Our ref: SL/2018/118397/04-L01
Your ref: EN010093
Date: 20 May 2019

WRITTEN REPRESENTATIONS.

**Application by Cory Riverside Energy for an order granting development
consent for the Riverside Energy Park - Riverside Energy Park, Belvedere,
South East London**

Written Representations on behalf of the Environment Agency

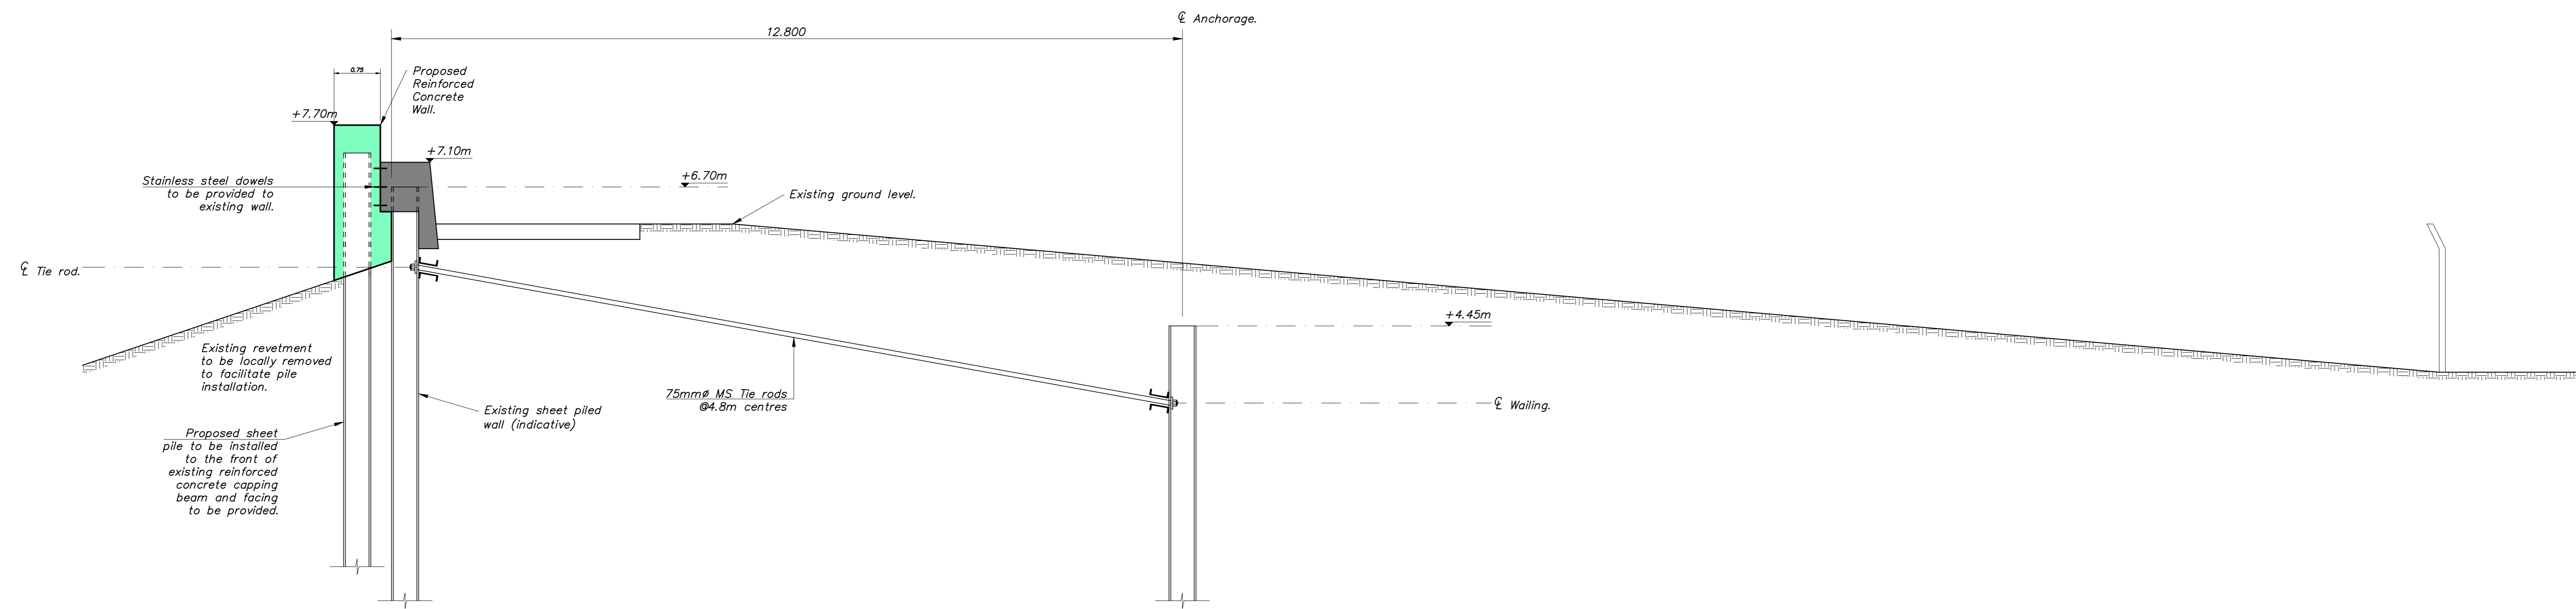
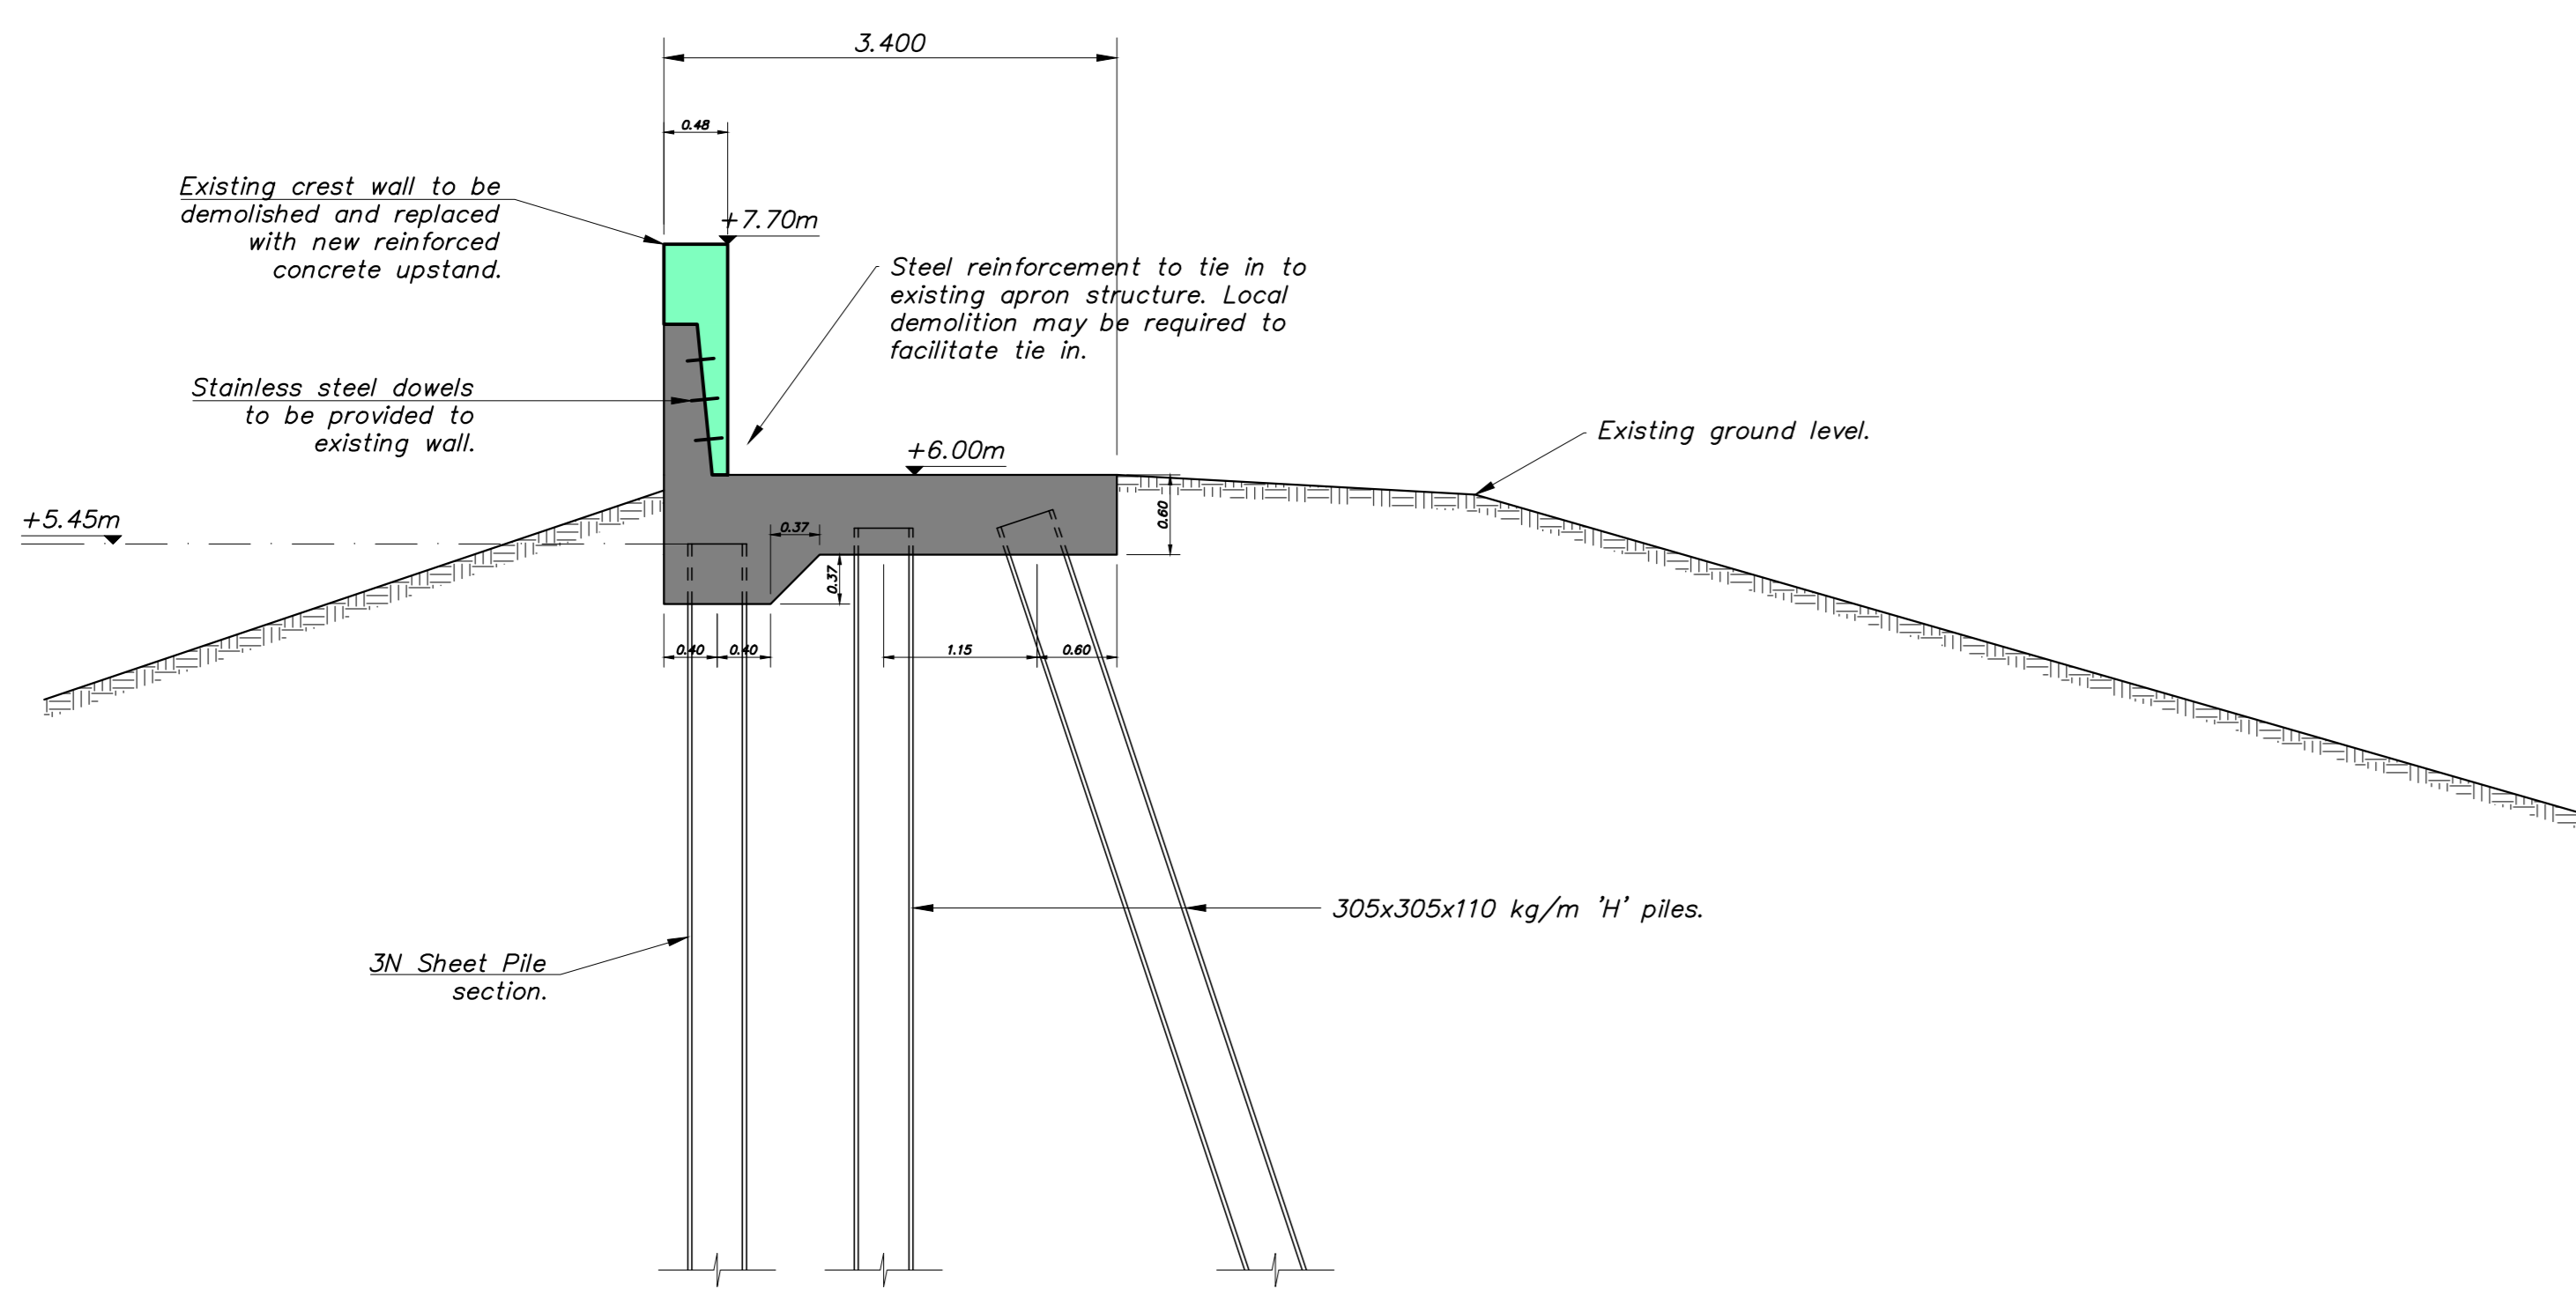
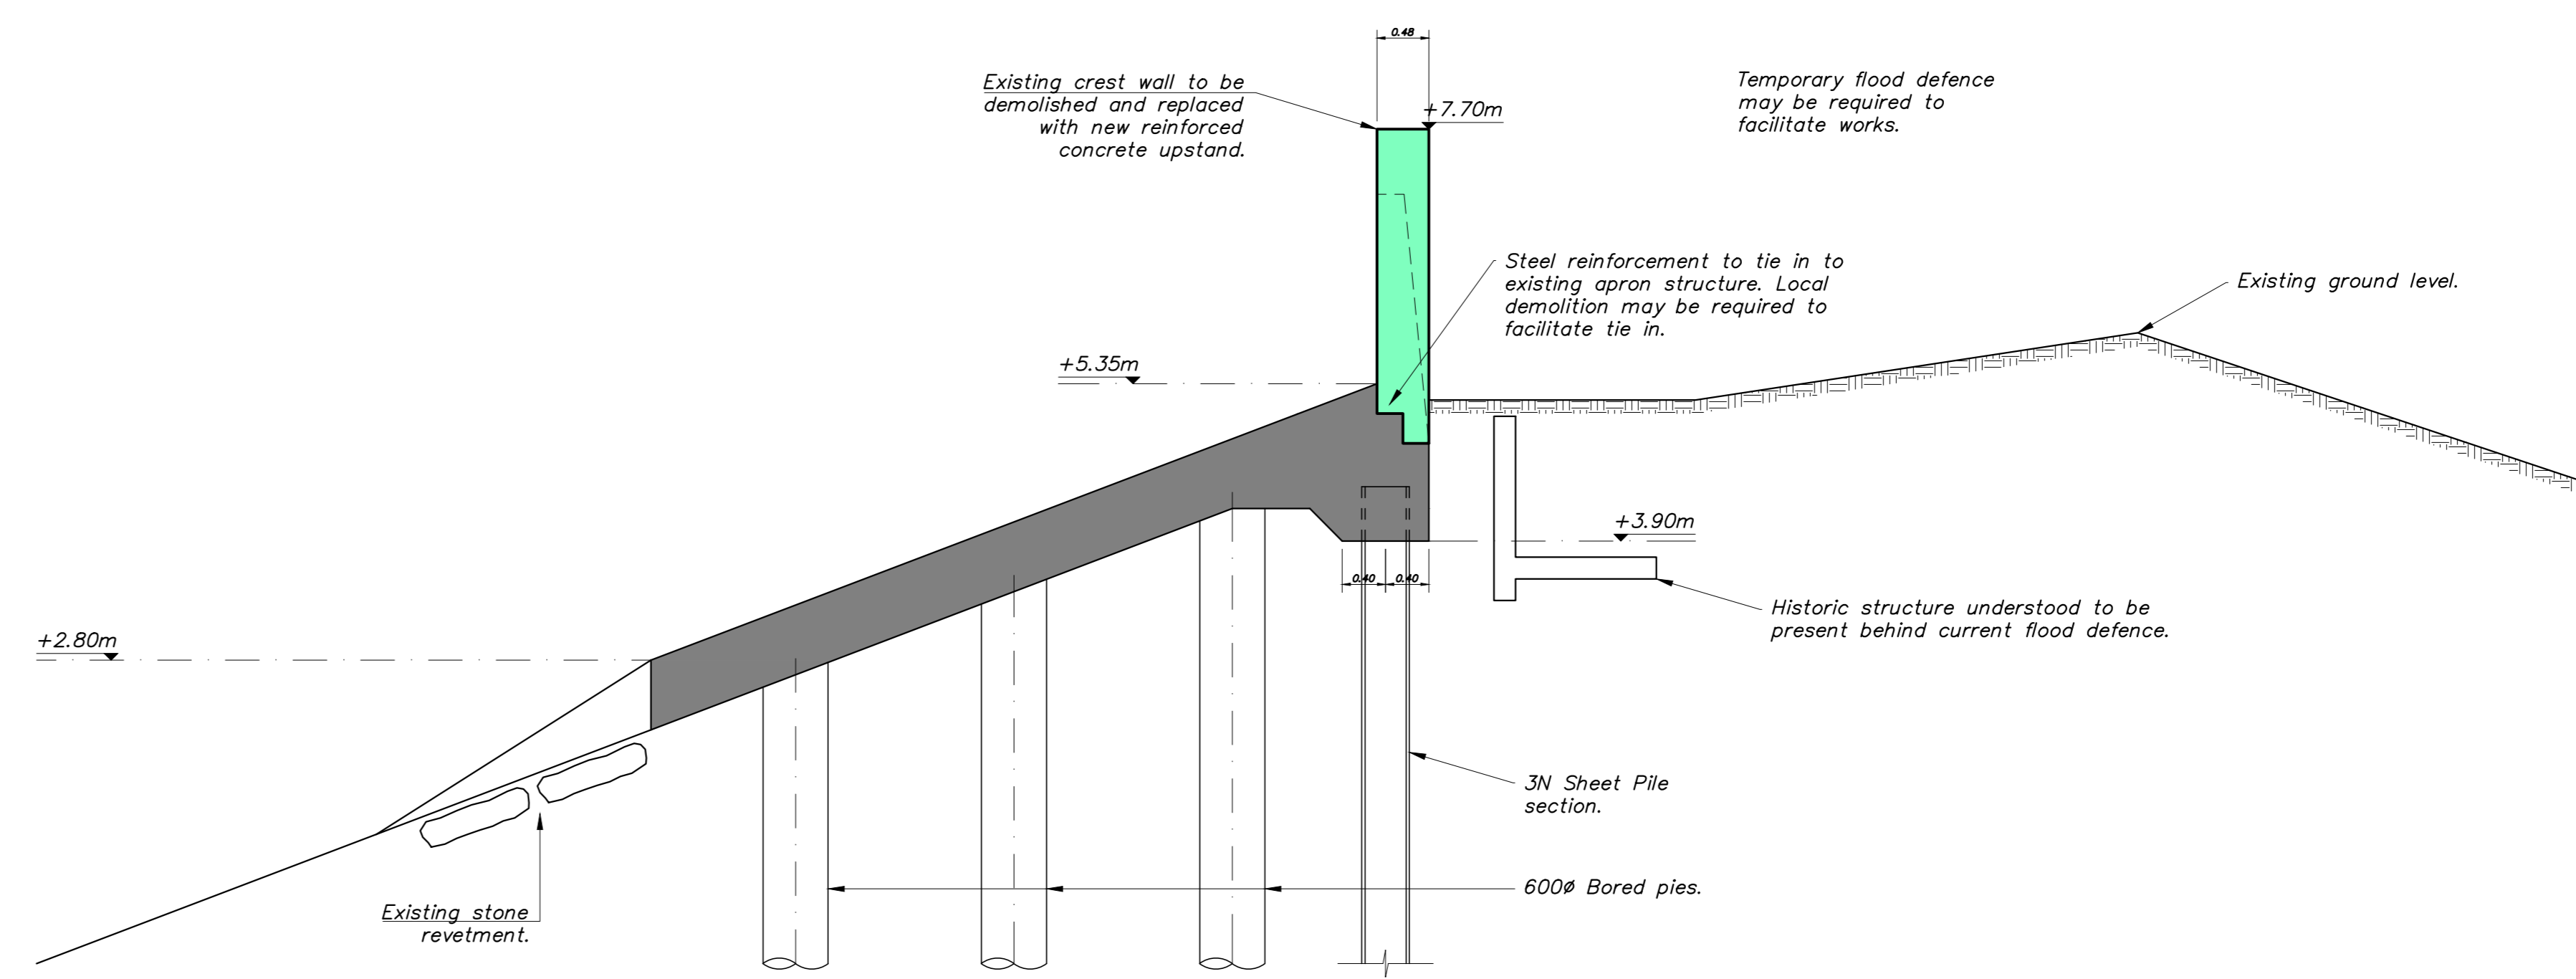
We have reviewed these drawing and are satisfied that it has been demonstrated that future raisings in line with the Thames Estuary 2100 Plan are possible once the REP has been constructed. These drawings are indicative to demonstrate that raising will be possible and do not necessarily reflect the scheme that will be implemented in the future. These drafts which are currently marked as draft should be submitted in support of the draft DCO.
